CITY OF PORTLAND, MAINE

December 2, 2013

Project Name: New Yard at Canal Landing, Phasing Amendment
Project ID: #2013-224
Address: 40 West Commercial Street
CBL: 59-A-1,2,3,4,5,6,7,8,9,10,11,12
Applicant: New yard, LLC
Planner: Bill Needelman, Senior Planner

DRAWN: CMW DATE: APR 2012  
 DESIGNED: RJW SCALE: 1" = 50'  
 CHECKED: SRB JOB NO. 3091  
 FILE NAME: 3091-SITE LAYOUT  
 SHEET: C-2.1

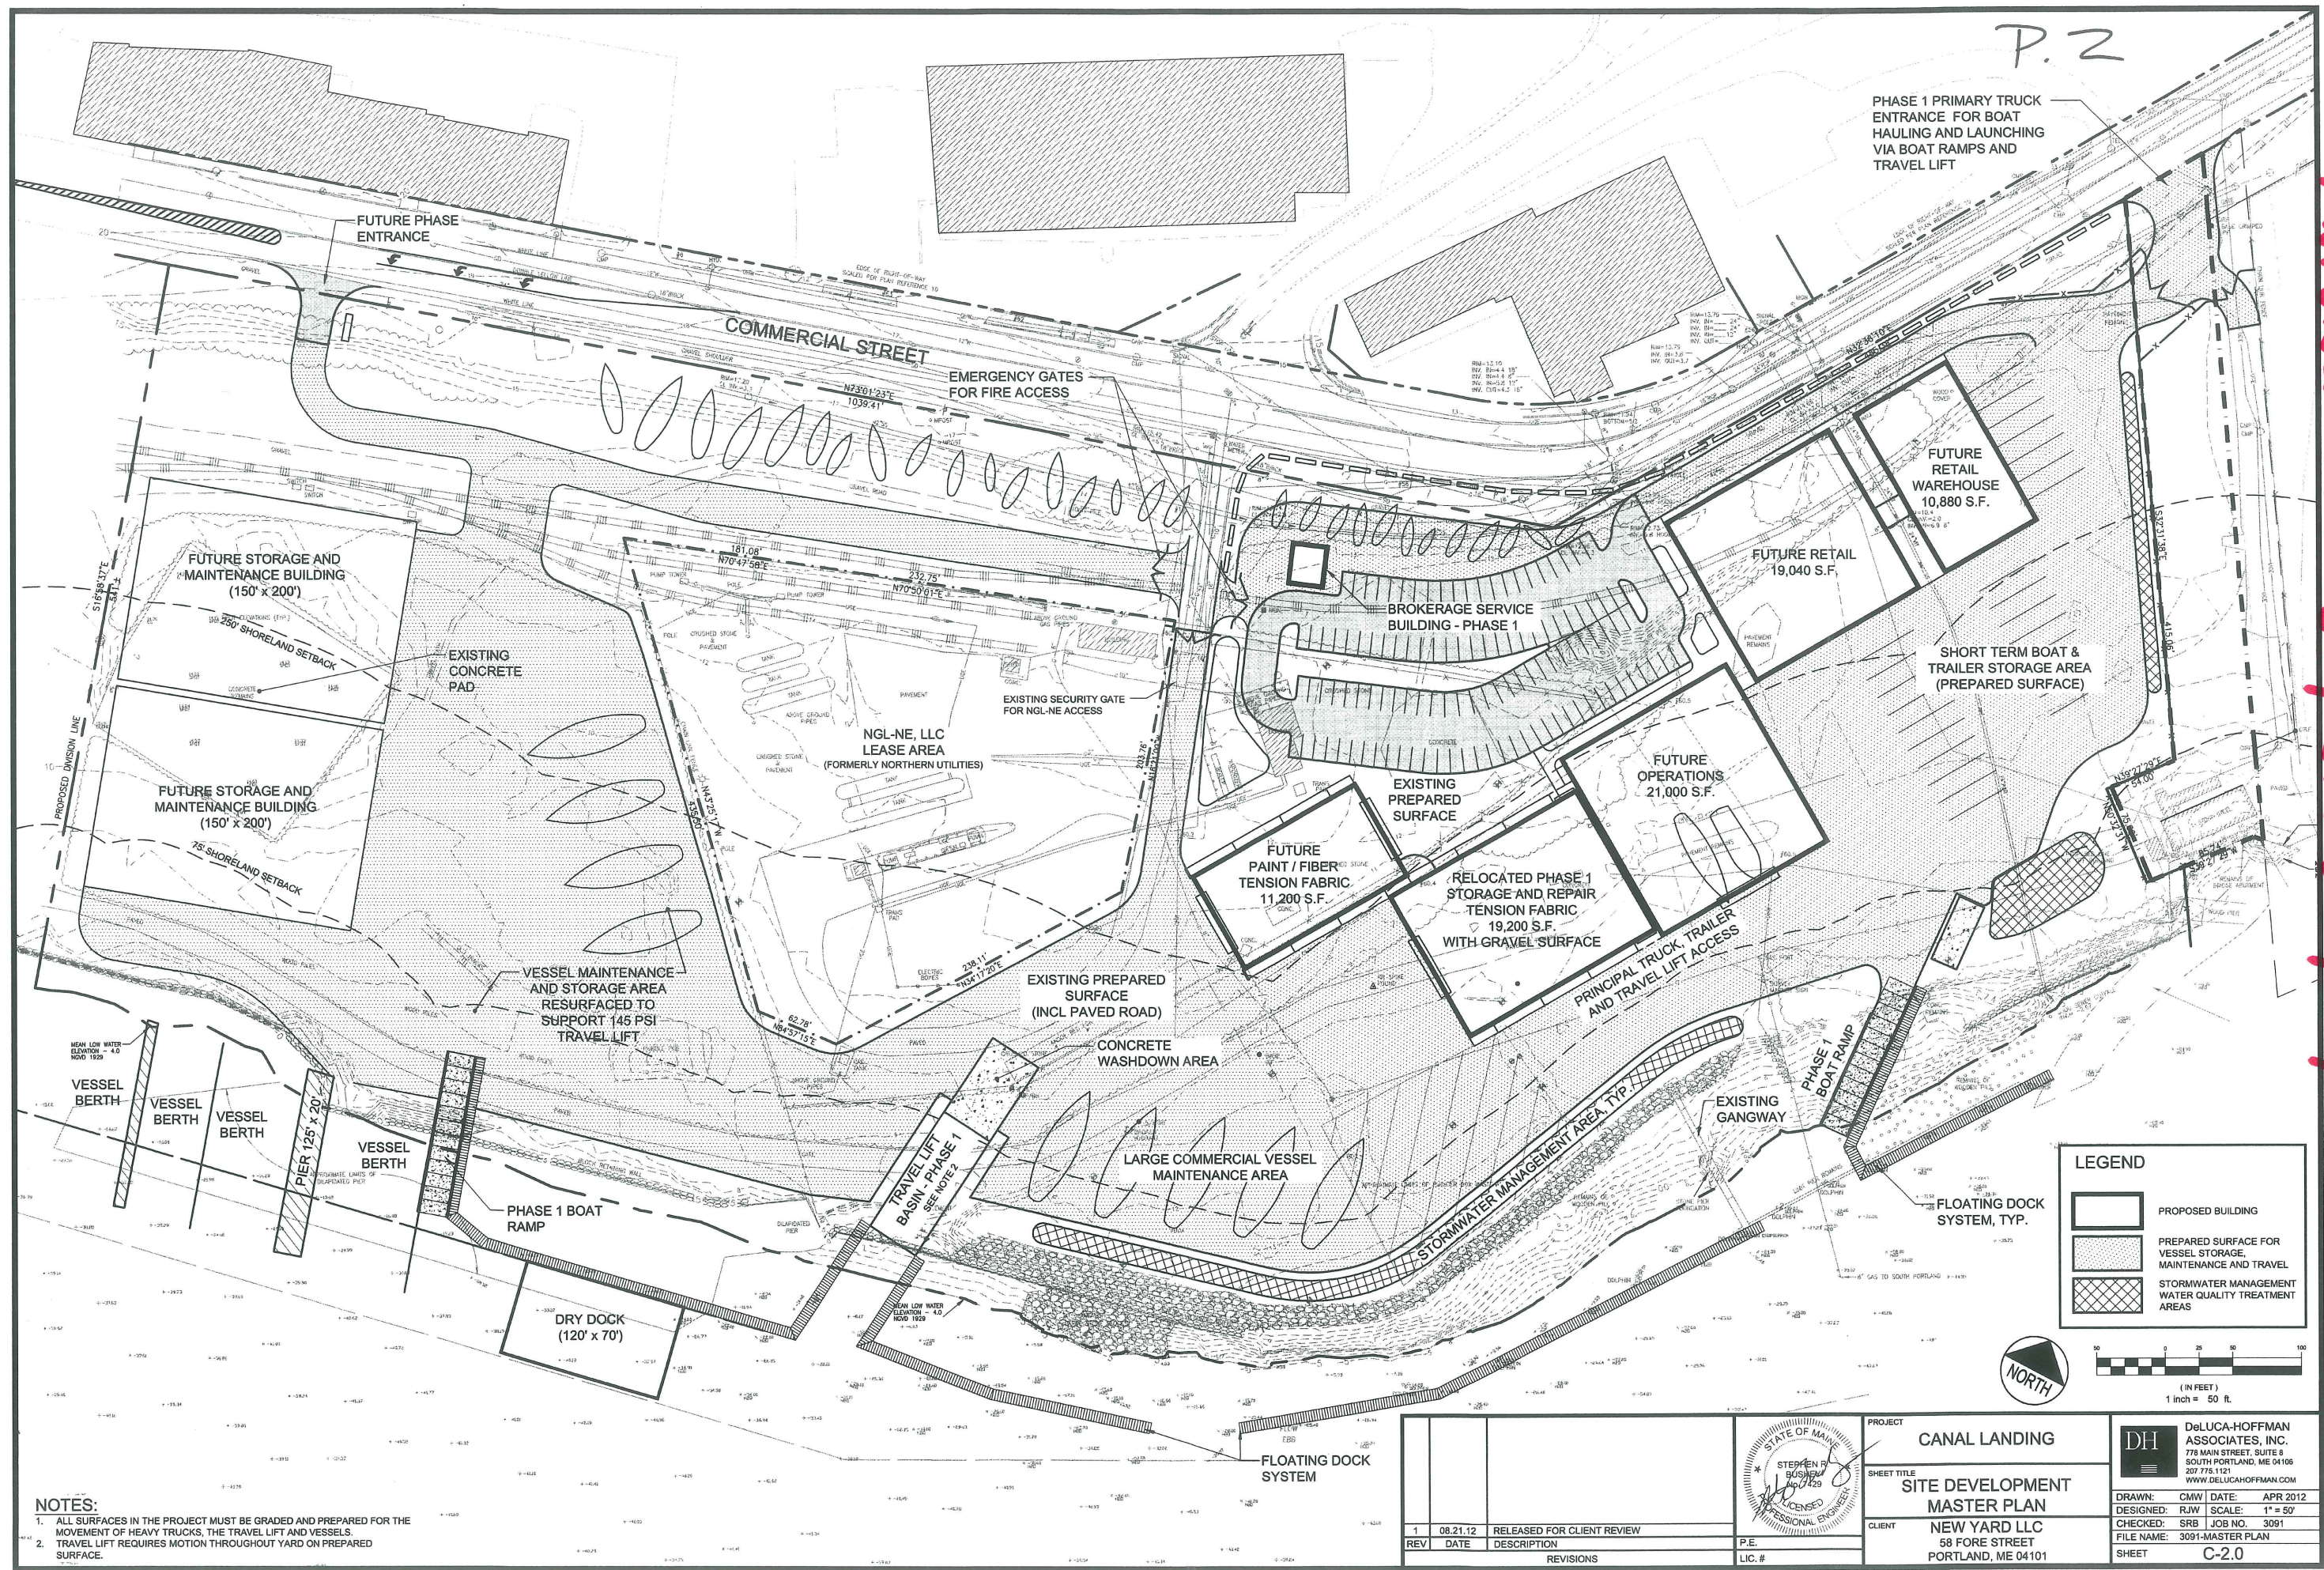
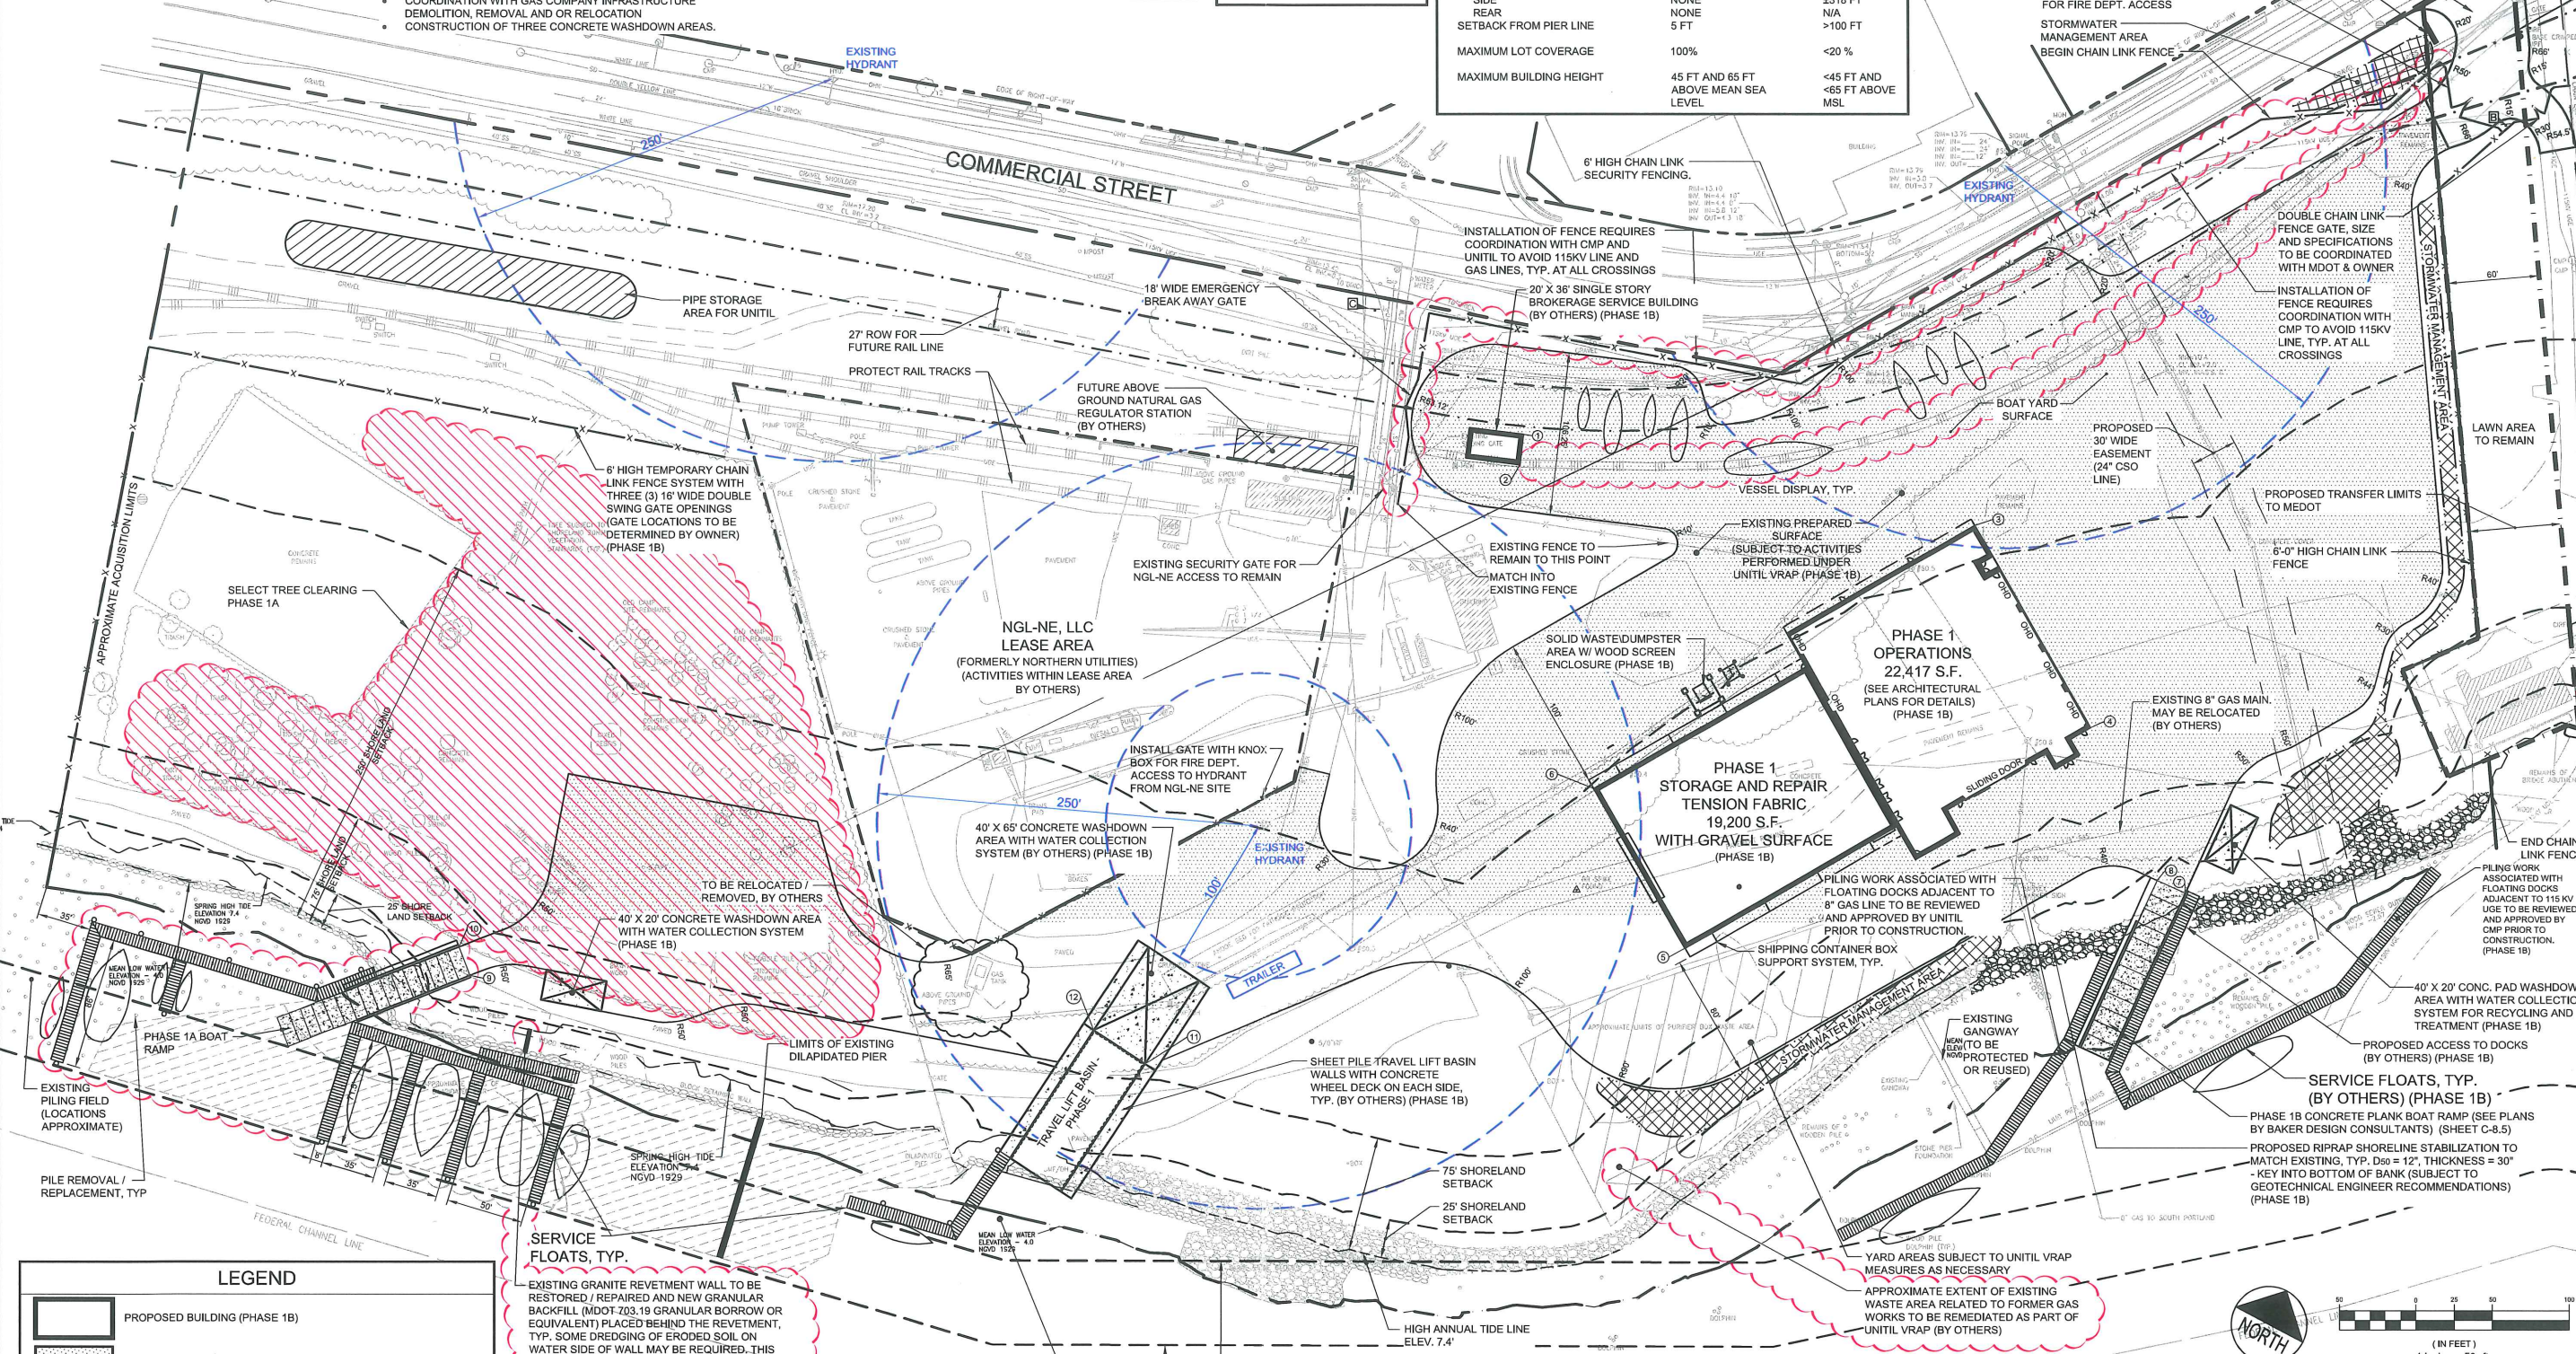
Requested Amendments: The amended plan moves the two primary buildings (retaining their approximate size,) eliminates 1 boat ramp and the travel lift basin, and significantly reduces the extent of berthing floats. The amended site plan is referred to as Phase 1B (sheet C-2.1) in the applicant’s material and labeled Attachment P8.

The proposed improvements included with the requested amendment are shown on Attachment P8 (Sheet C-2.1).

PROJECT: CANAL LANDING (PHASE 1A)  
 TITLE: FIRE PROTECTION PLAN PHASE 1A ONLY  
 CLIENT: NEW YARD LLC  
 58 FORE STREET  
 PORTLAND, ME 04101

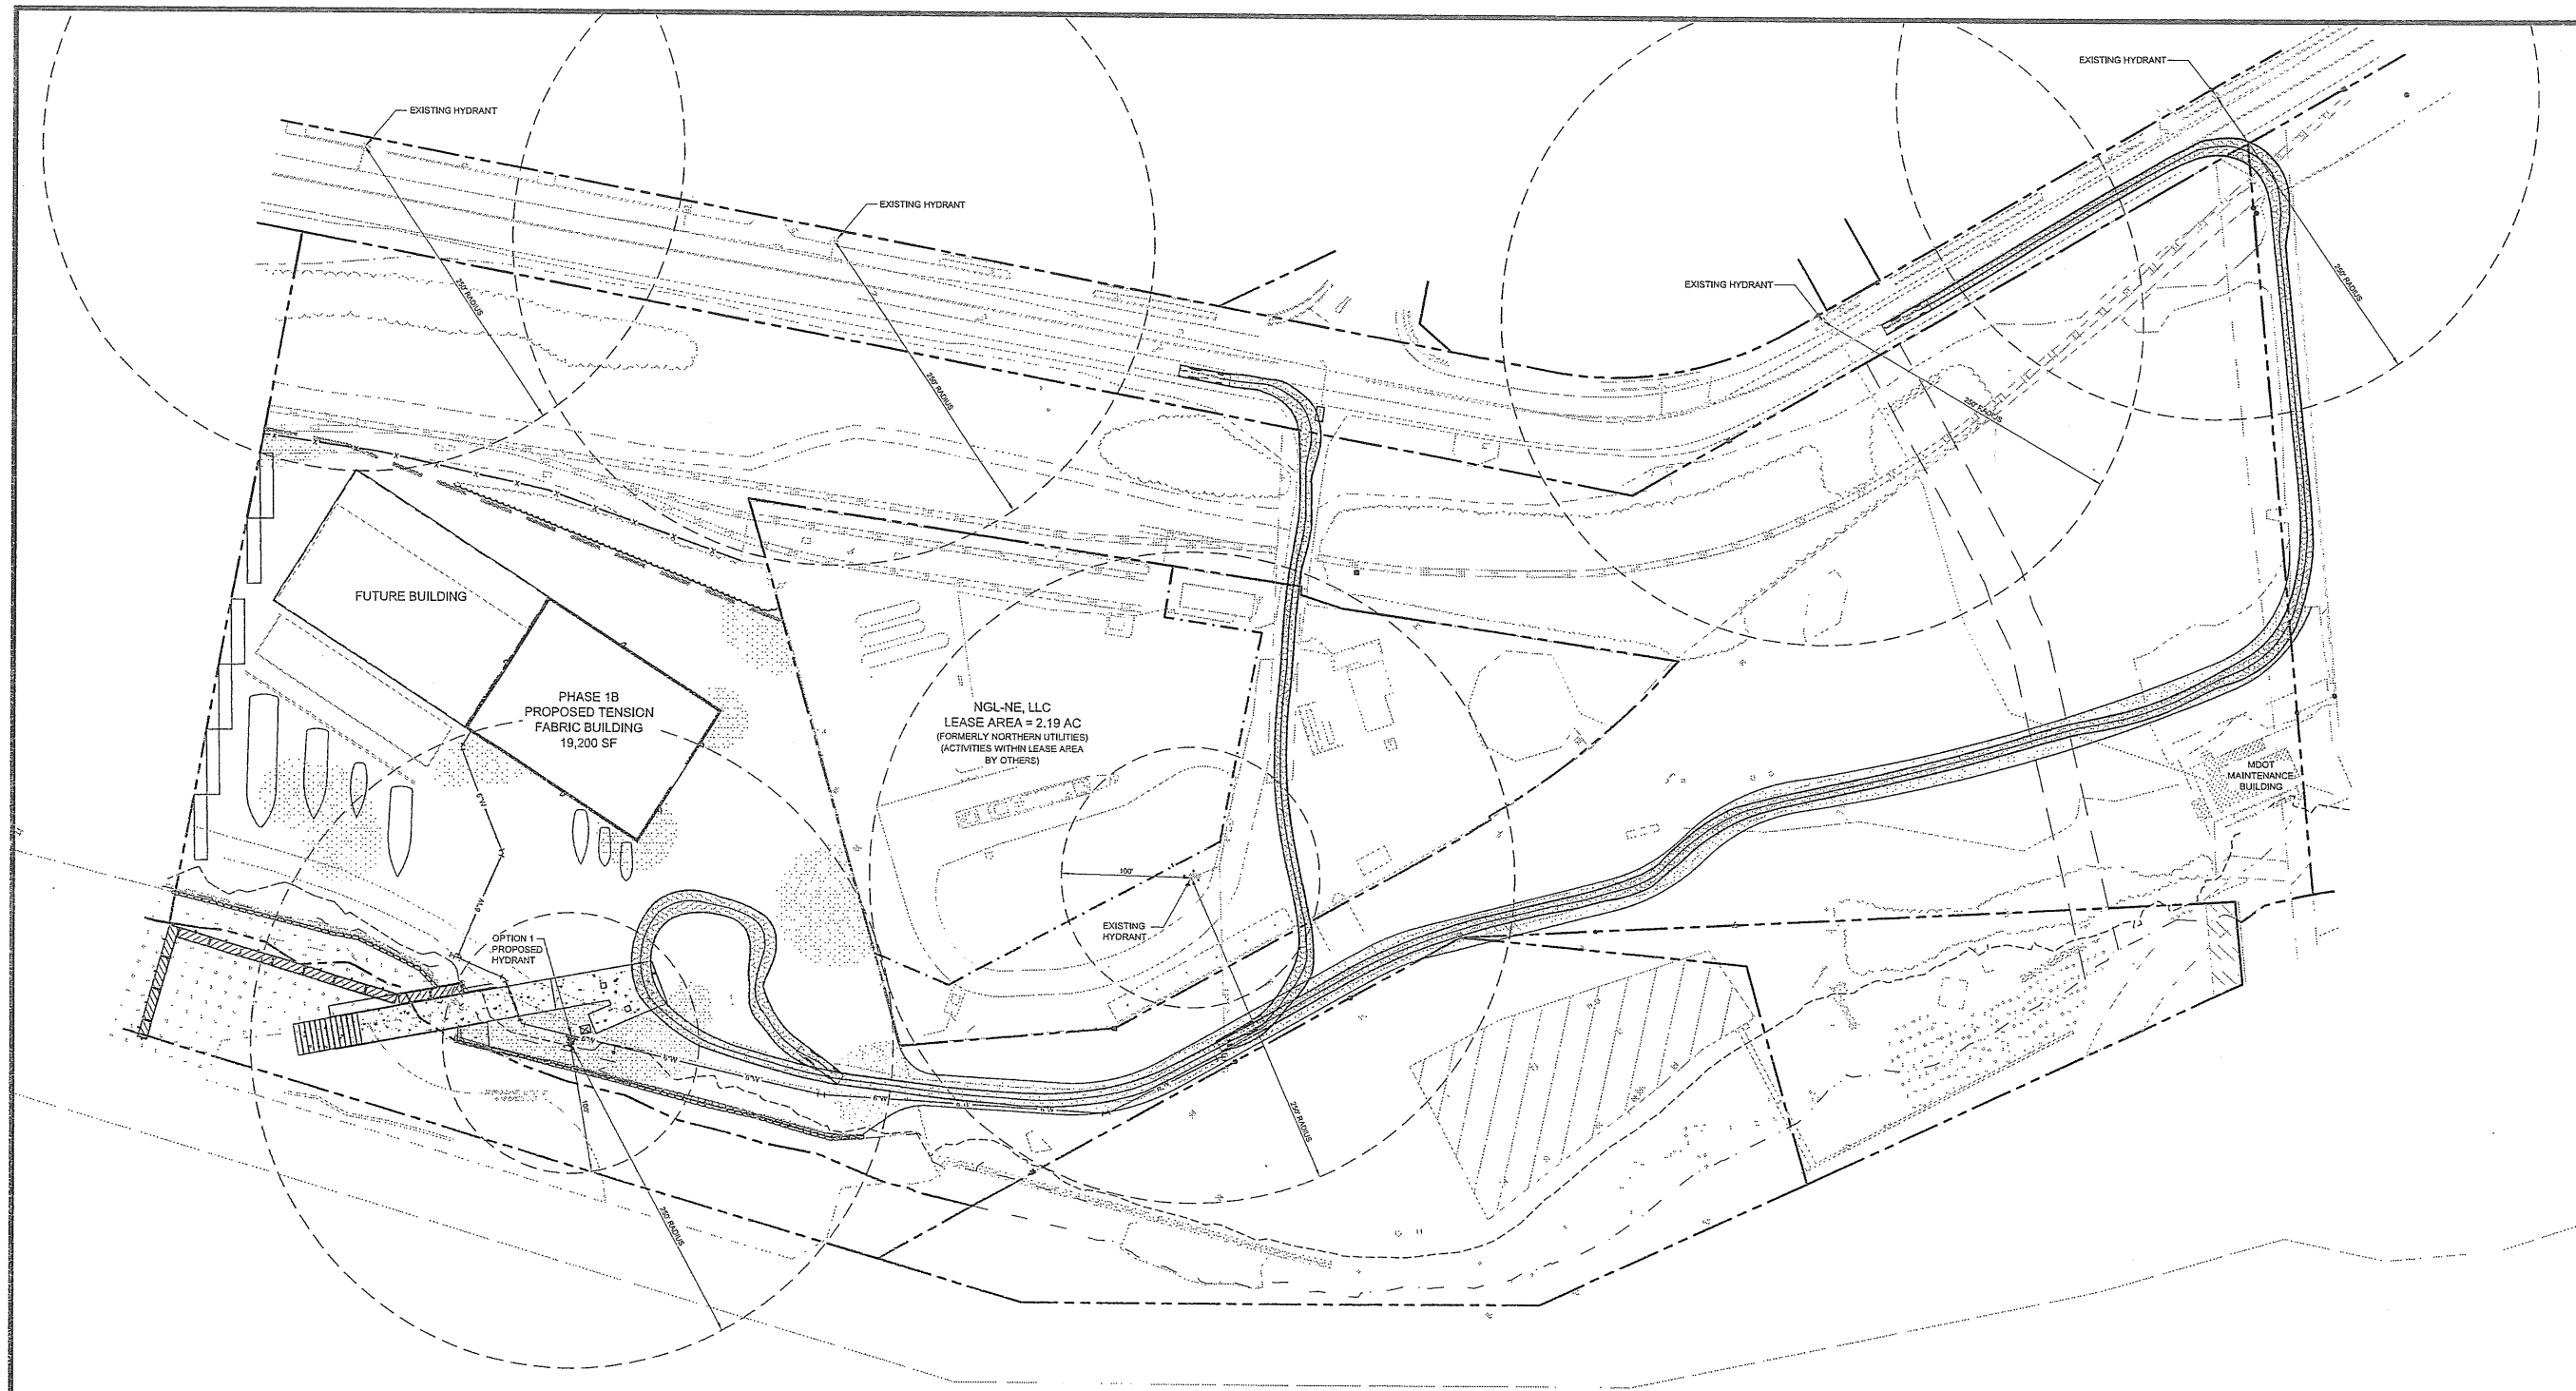
- ii. Fire Safety and Emergency Access: *Prior to issuance of a building permit, the revised fire access and circulation plan, as may be amended, shall receive review and approval from City Fire Safety review staff.*
